Application: SSI 7485

I write regarding the proposed modification to M4-M5 Link, Mod 2 The Crescent overpass and changes to pedestrian infrastructure in North Annandale, Rozelle and Rozelle Bay Foreshore area.

**Figure 4 | Proposed modification** (Source: Design Amendment Report)

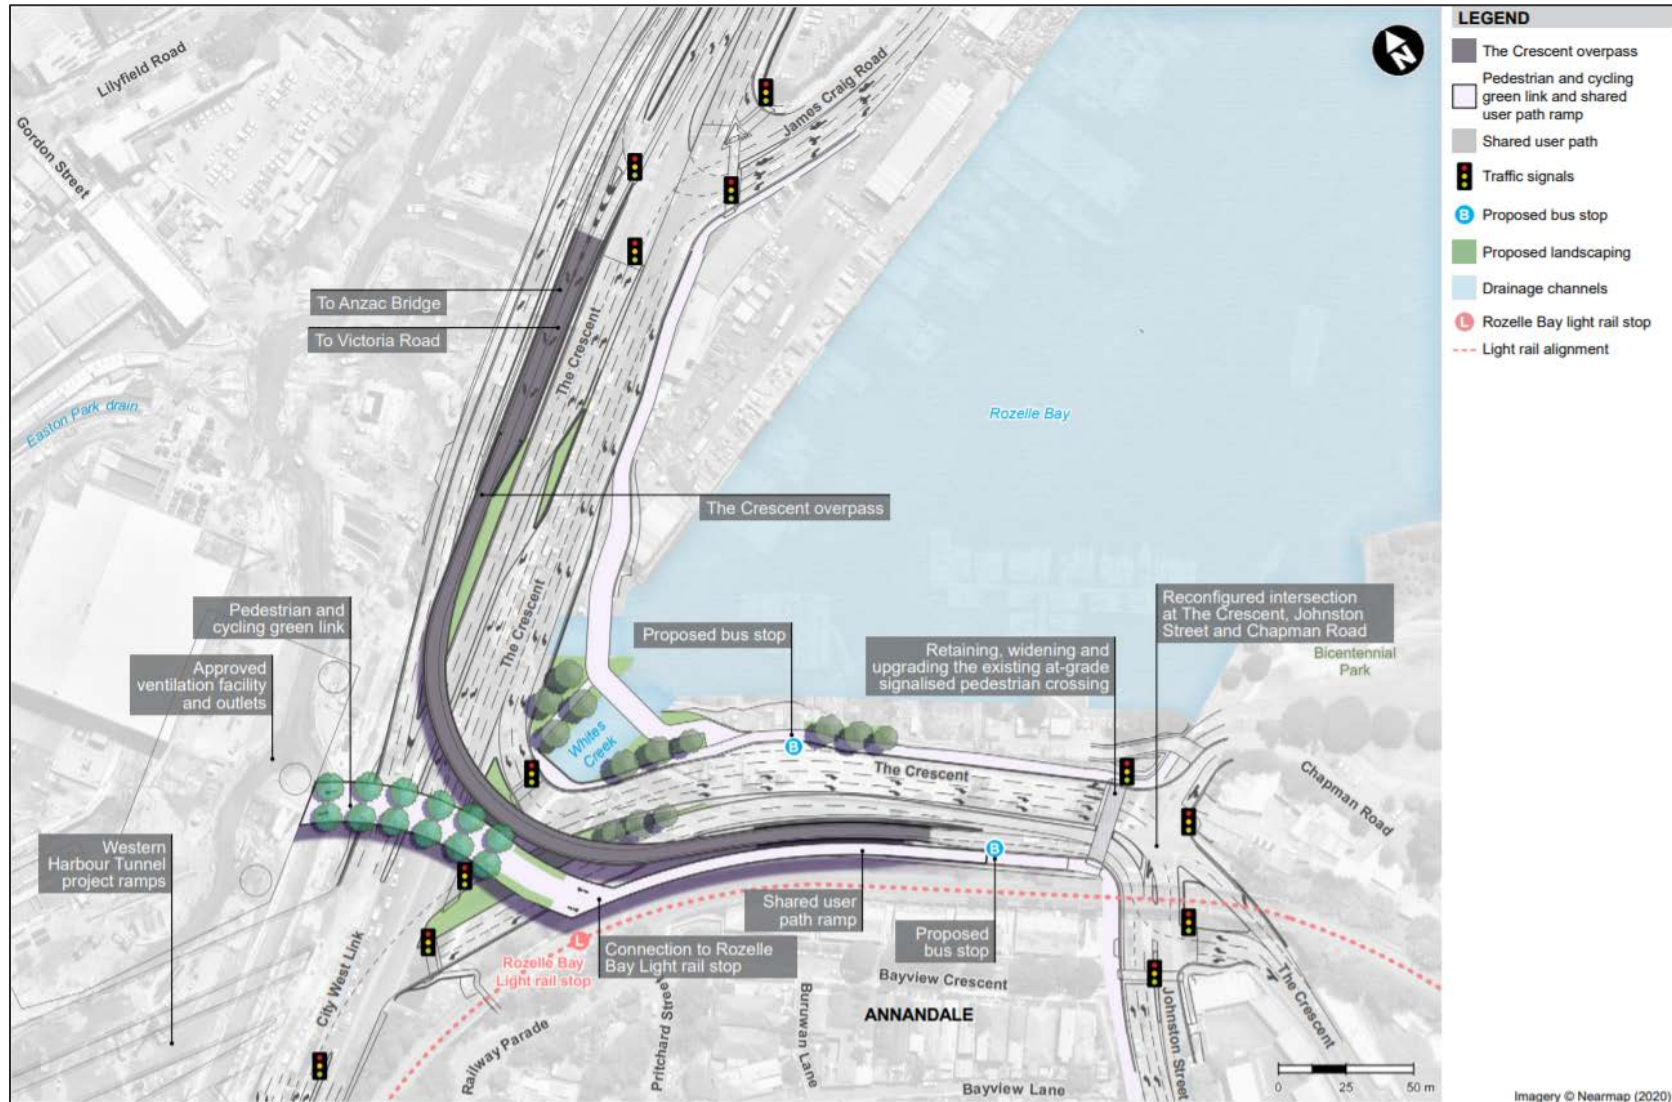
I request RMS work with the community to explore alternate design options to the proposed new car overpass design and the changed pedestrian and cyclist links. I am seeking the reinstatement of the safe, direct access from the approved EIS GreenLink to create a continuous green open space connection from the Rozelle Rail yards and Annandale to the foreshore. The GreenLink was more than just a walk way - it put people central to the design, maximising safety, and providing much needed accessible open space for the community now and into the future Bays Precinct design.

- The significantly reduced safety and increased risk for pedestrians and cyclists with removed access over The Crescent to Bicentennial Park and the increased traffic along Johnson Street.
- Being required to cross five sets of pedestrian lights at The Crescent as my option to reach the foreshore from Annandale or from Rozelle Bay light rail stop.
- Removal of direct active links to the foreshore, cutting the community off from the area and the proposed revitalisation of the entire Bays Precinct, including linking the Light Rail and Bus stops to a Ferry wharf and Metro station.
- Urban and landscape design that is being built before a finalised Masterplan for the area.
- Traffic changes that limit movements around the suburb and create further congestion in the local streets of Annandale, Forest Lodge, Glebe, Lilyfield and Rozelle with no planning to deal with these.

- Reinstate the GreenLink connecting communities and green open space from Rozelle to Bicentennial Park
- Relocate and design pedestrian and cyclist connections that are continuous, safe and direct.
- Design the modification infrastructure and active links in response to the character of the suburbs, the location of the foreshore and it's potential future development.
- Provide pedestrian and cyclist paths that maximise people safety and do not force them onto busier streets, unsafe concrete plazas and caged walkways.
- Integrate active and direct connections to all active transport – including the future Metro West and Foreshore Ferry Wharf

I urge the Govt to listen to community concerns
and redesign the car overpass, greenlink &
transport links to deliver positive outcomes
for all.
